Memorandum
Planning and Urban Development Department
Planning Division

Date: February 23, 2018

Re: MMC East Tower and Visitor Garage Vertical Expansion
 22 Bramhall Street
 Maine Medical Center (MMC)

Project #: 2017-289 CBL: 053D007/054H001/064C001

[ Visitors Garage ] Logistics Plans and Studies

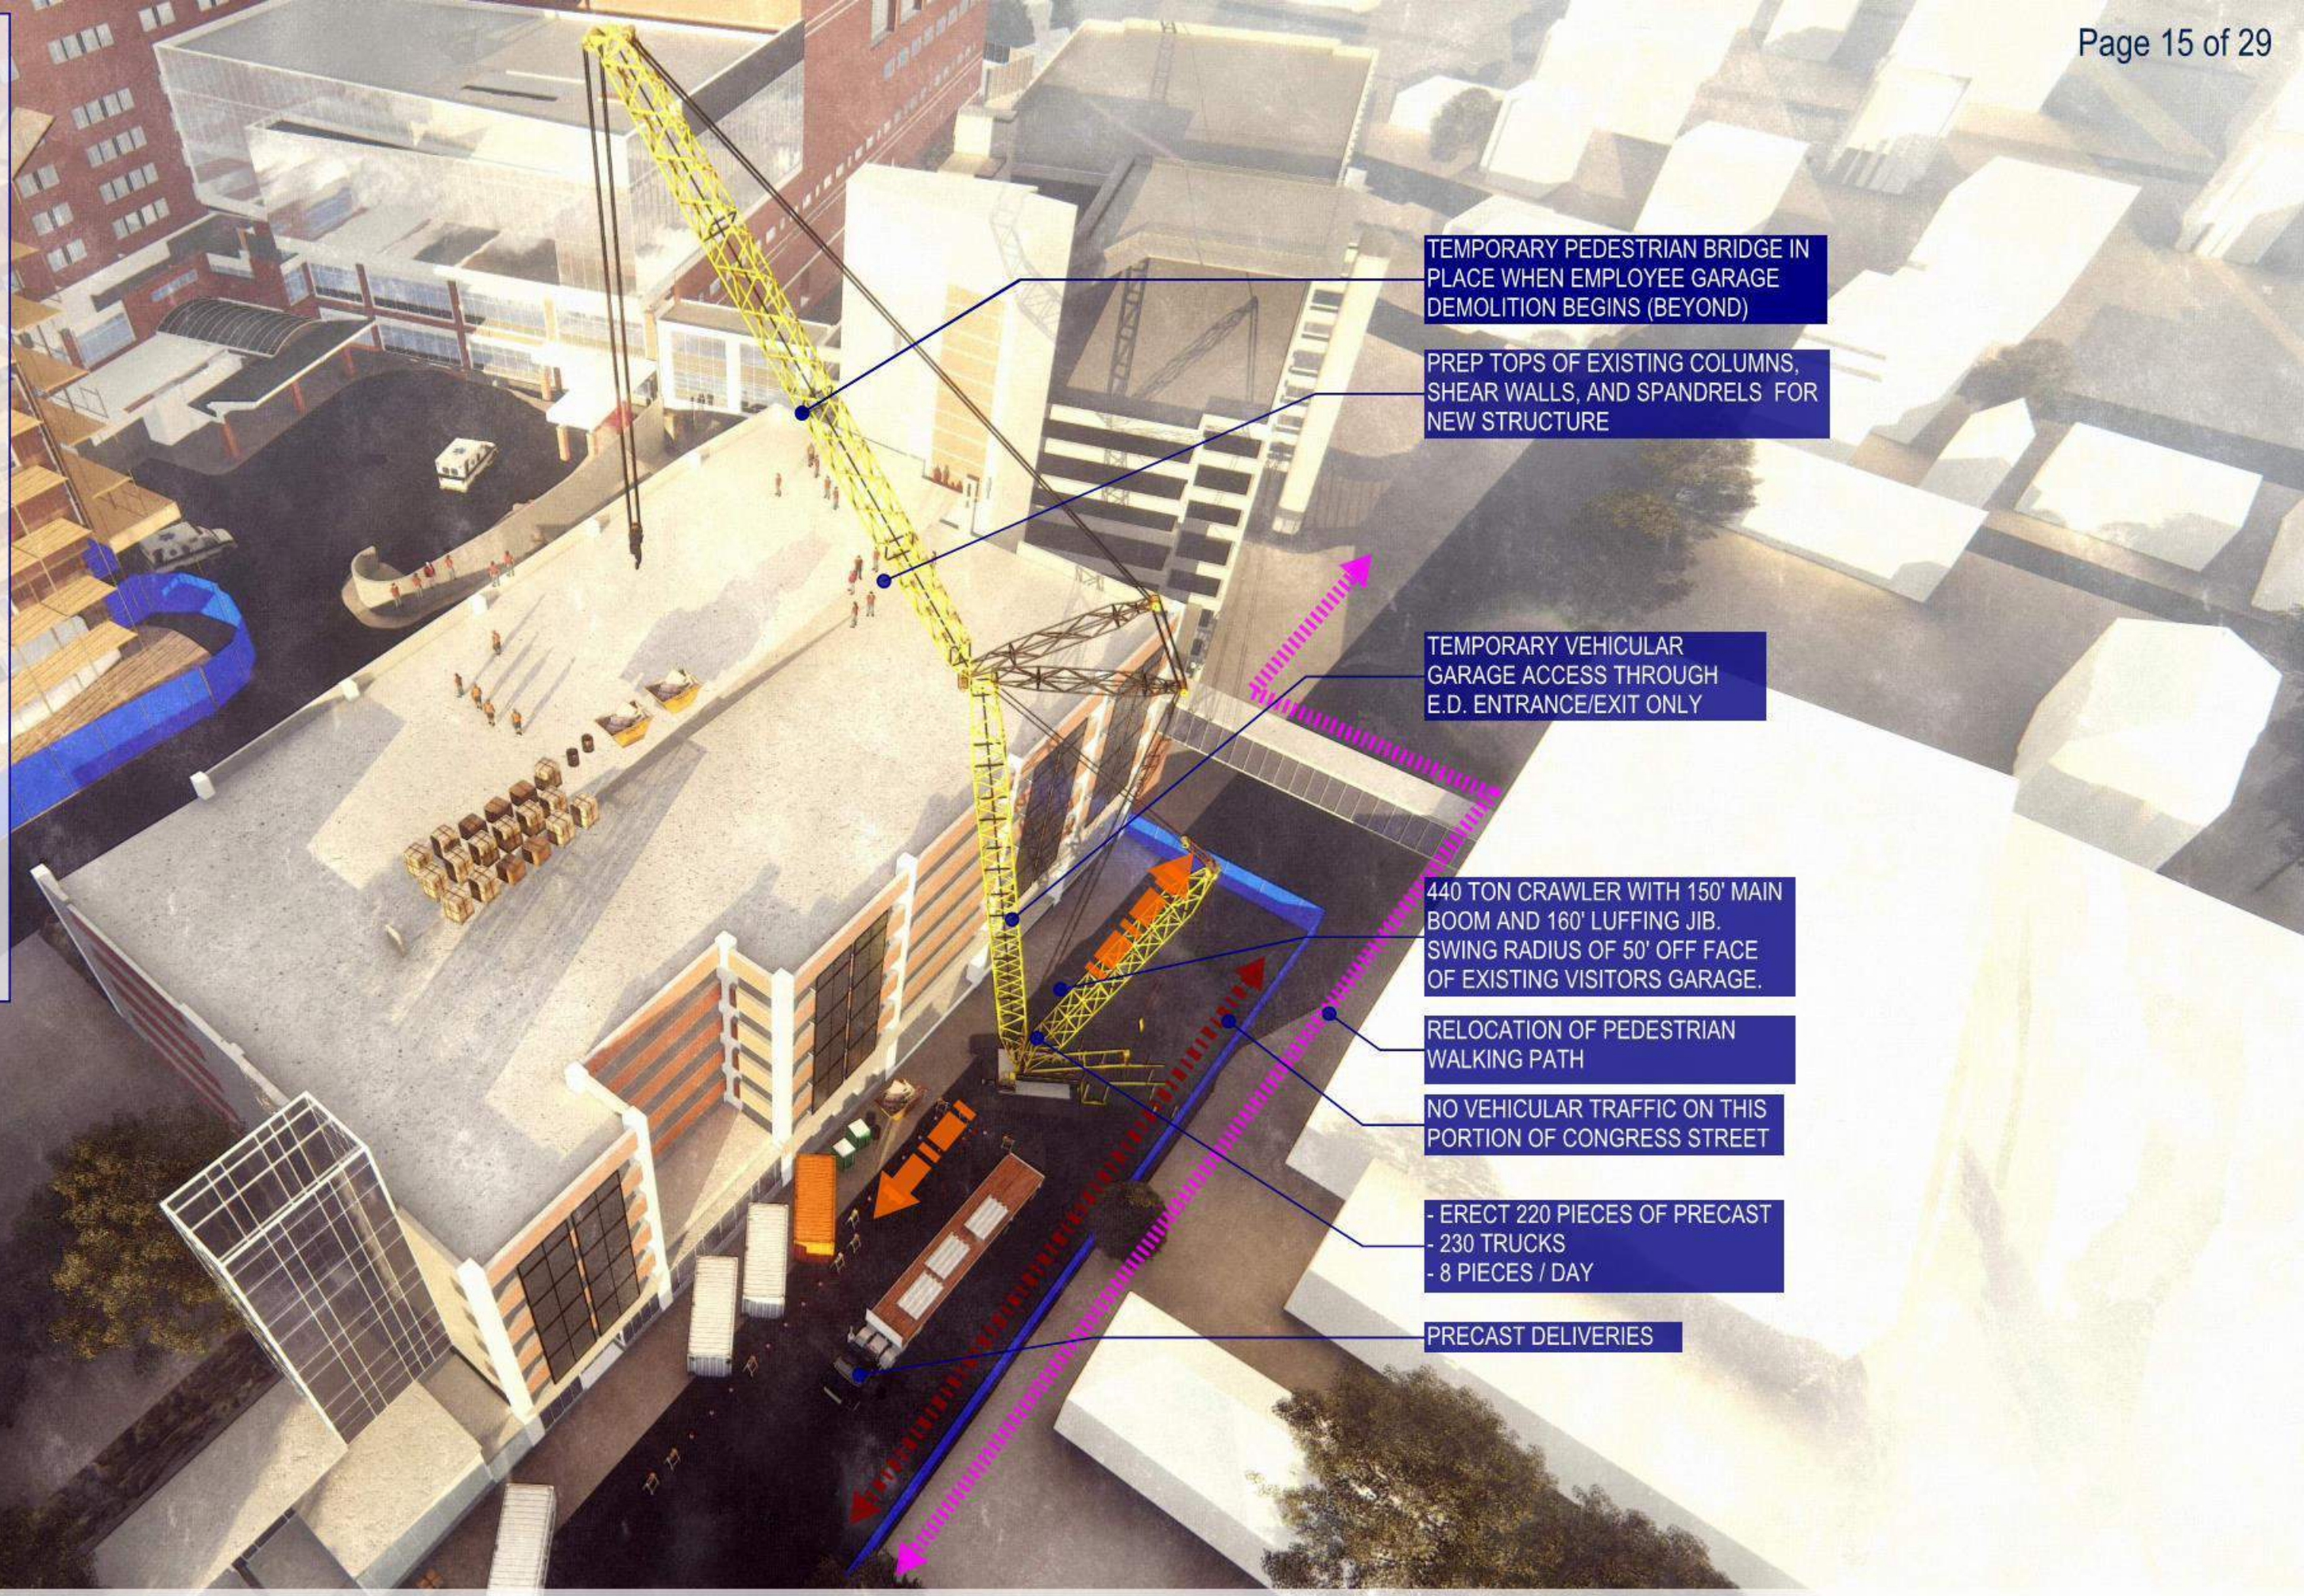
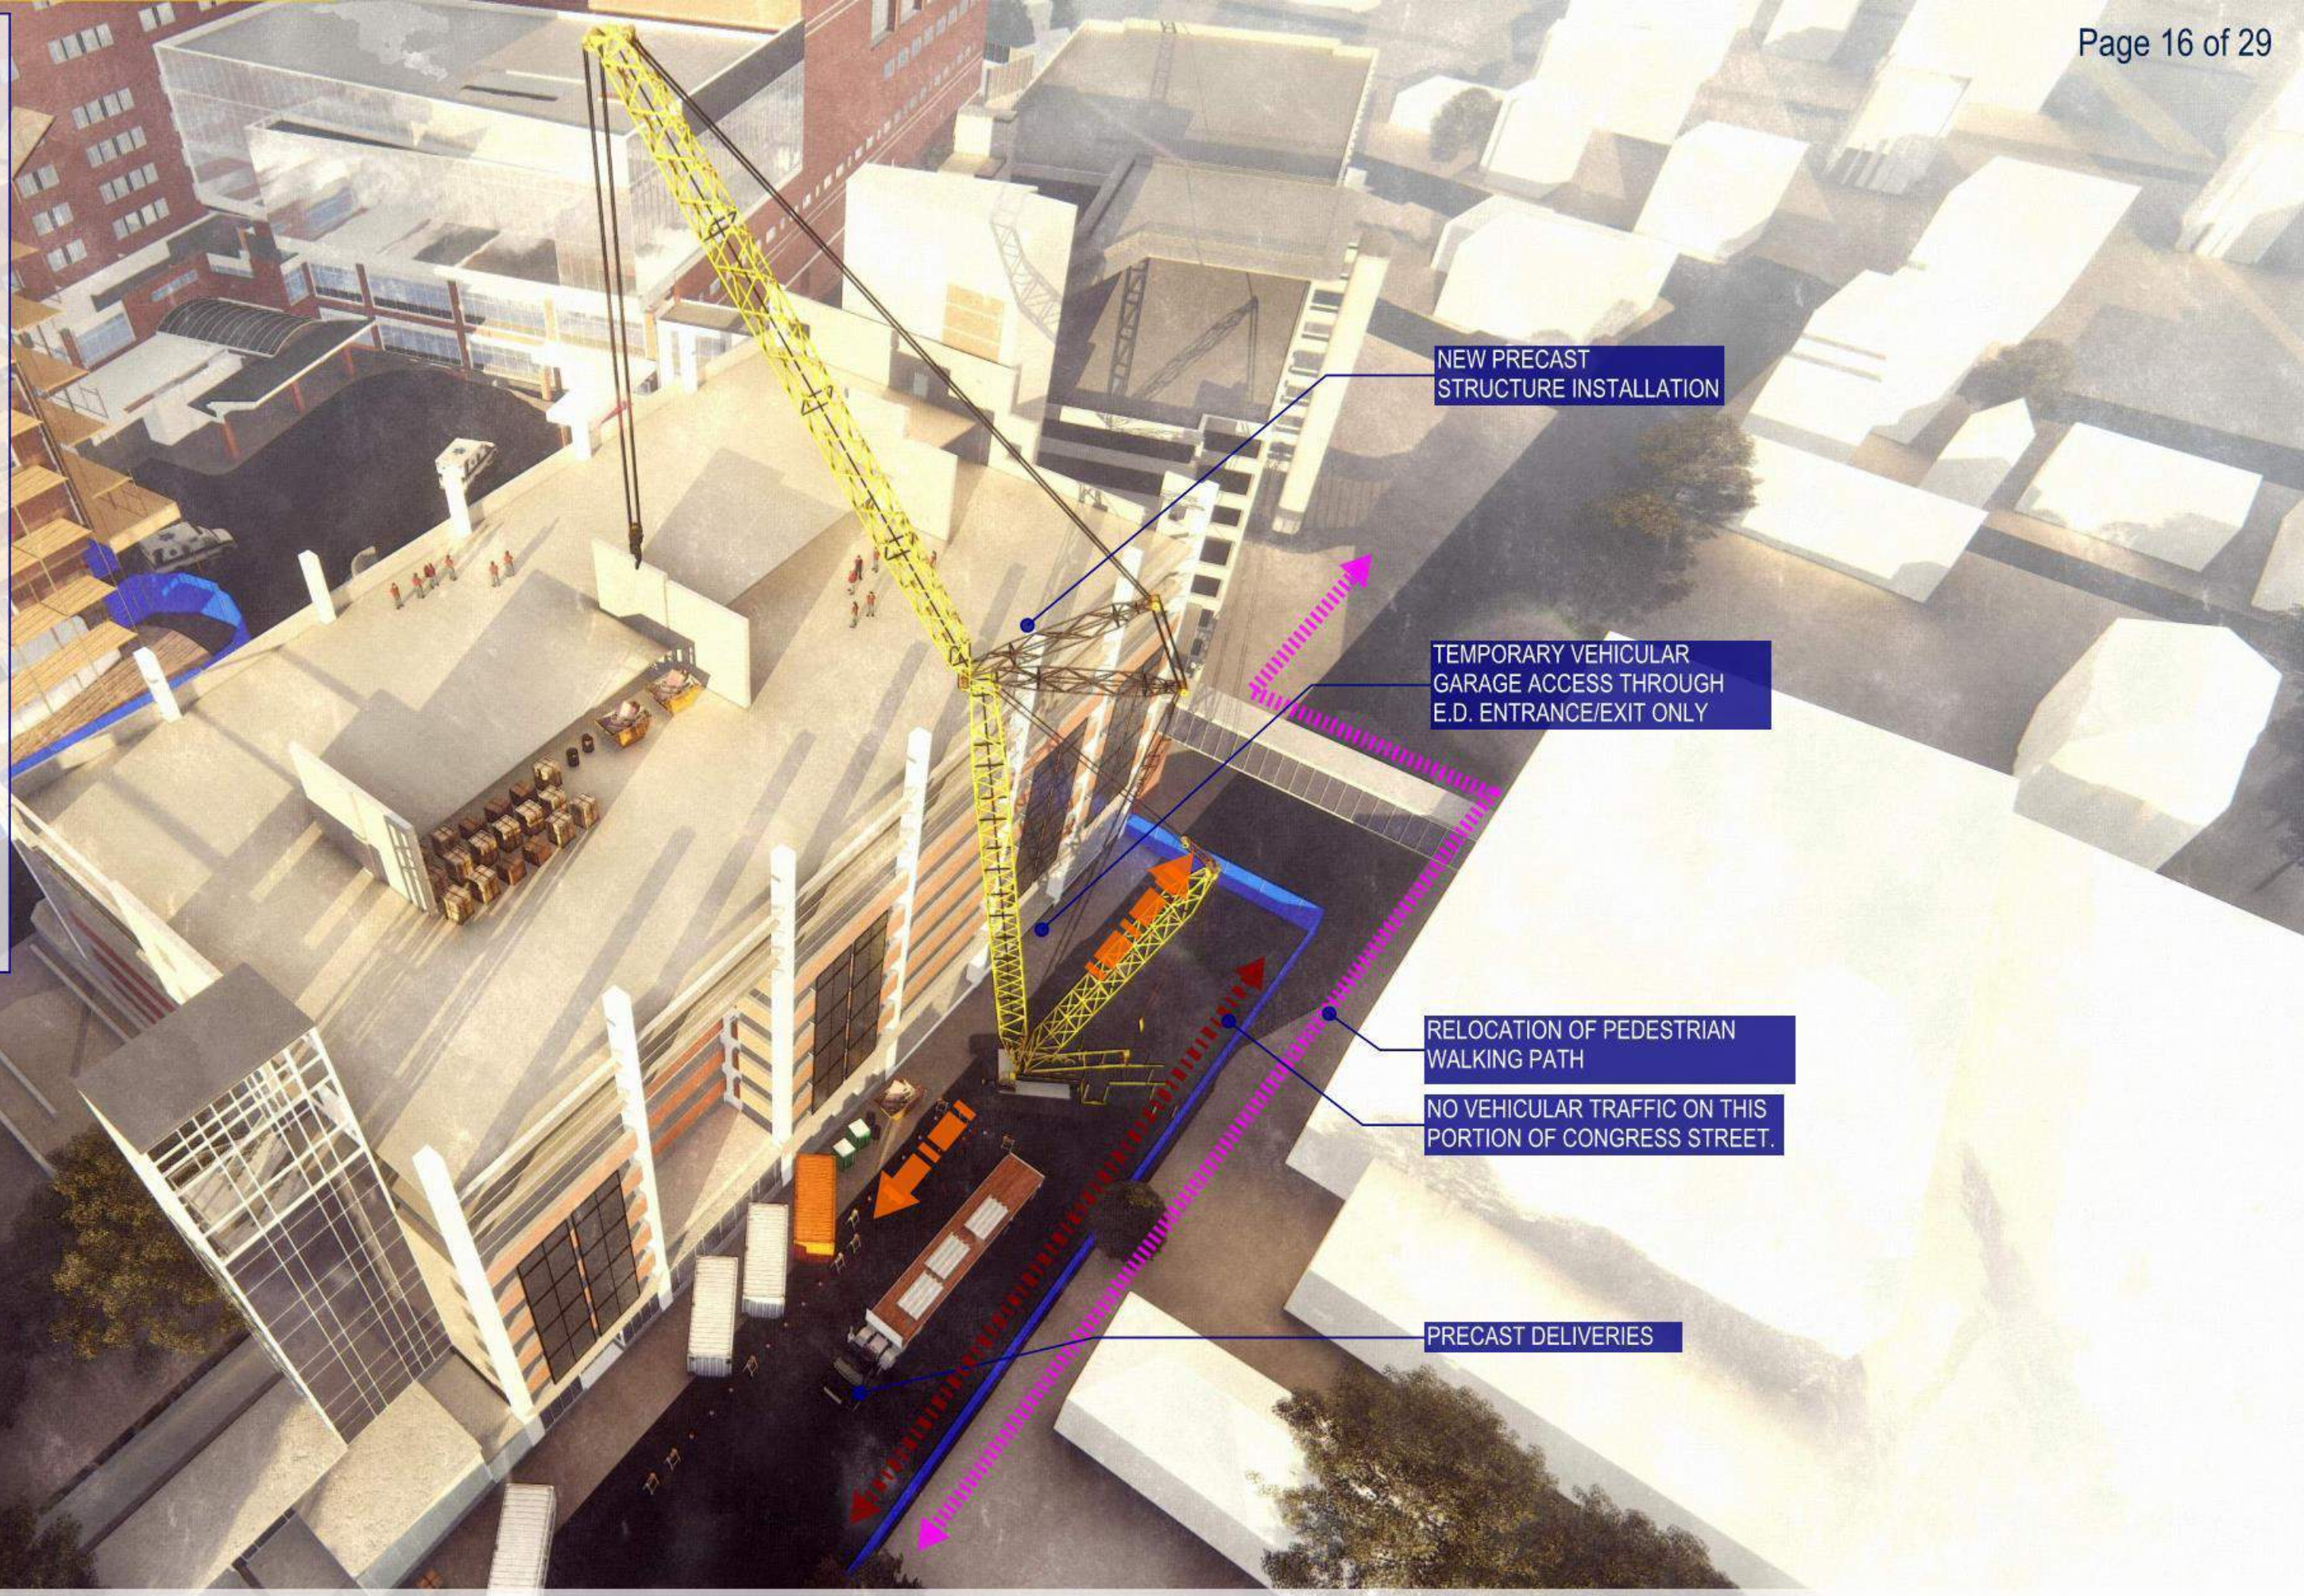
At the review “check in” meetings (Att. 6) there was general agreement that the 8 week closure of Congress Street presented the safest approach with the fewest “unknowns”, but there remain some concerns that require further discussion:

- The feasibility of the pedestrian route alongside the crane in Congress Street (the crane at right is the type of crane that will be needed)
- The delivery route for the steel for the East Tower is proposed to go via Washington Avenue and Congress Street
- Delivery hours to avoid peak traffic times
- Enforcement of contractor employee parking not to be on local streets
- Introduction of penalties and other measures to ensure the closure is reopened prior the July 4th holiday weekend.
